**WEST SUSSEX COUNTY COUNCIL
INFRASTRUCTURE CONSULTATION**

DATE: 08/12/2009

SUBJECT: LU/304/09 New Cottage, Toddington Lane, Wick, Littlehampton

**Demolition of existing dwelling and garage and redevelopment to provide 4
no. 3 bedroom houses and 2 no. 4 bedroom houses with new access off
Toddington Lane**

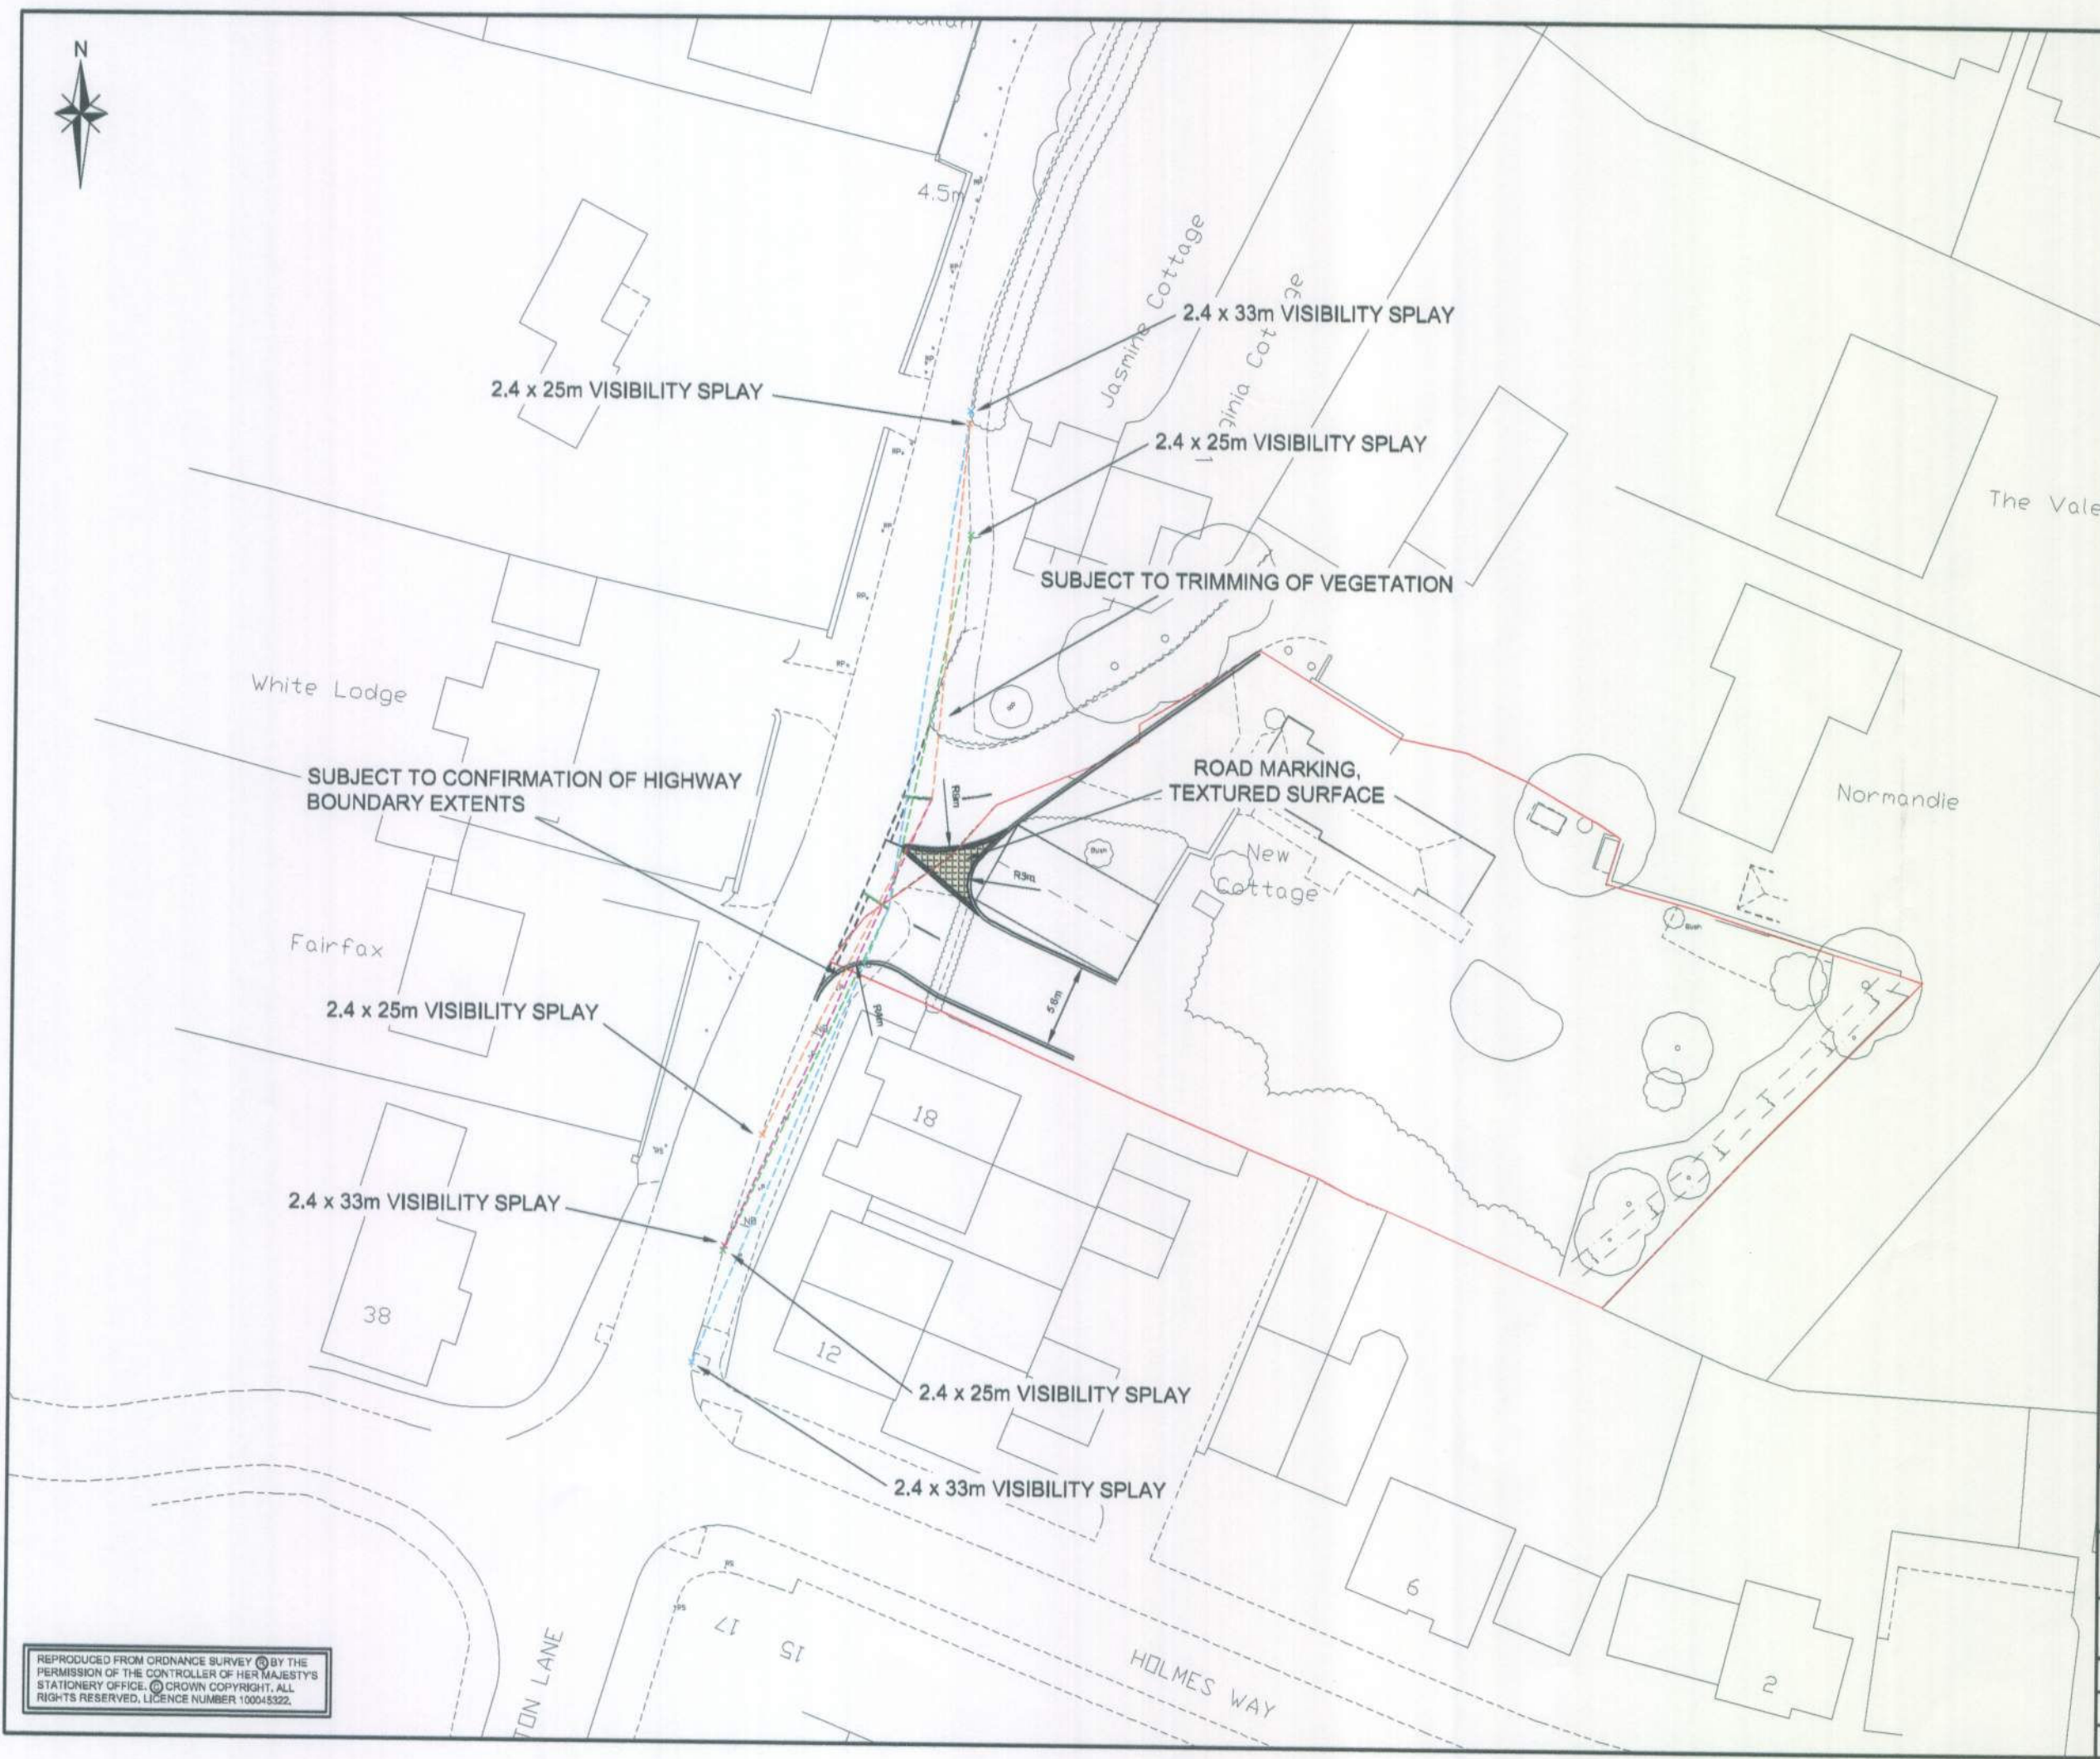
However, from the limited amount of information that we have available, it appears that the sightline to the south falls over land that is neither under the control of the applicant or the highway authority, i.e. it falls under the control of a third party. Until such times as the applicant can demonstrate that a sightline of 2.4m x 33m with no obstruction above a height of 900mm above carriageway level can be provided and fully controlled, then the application should be resisted.

RN5 – The proposal does not make provision for adequate visibility at the junction of the access with the public highway.
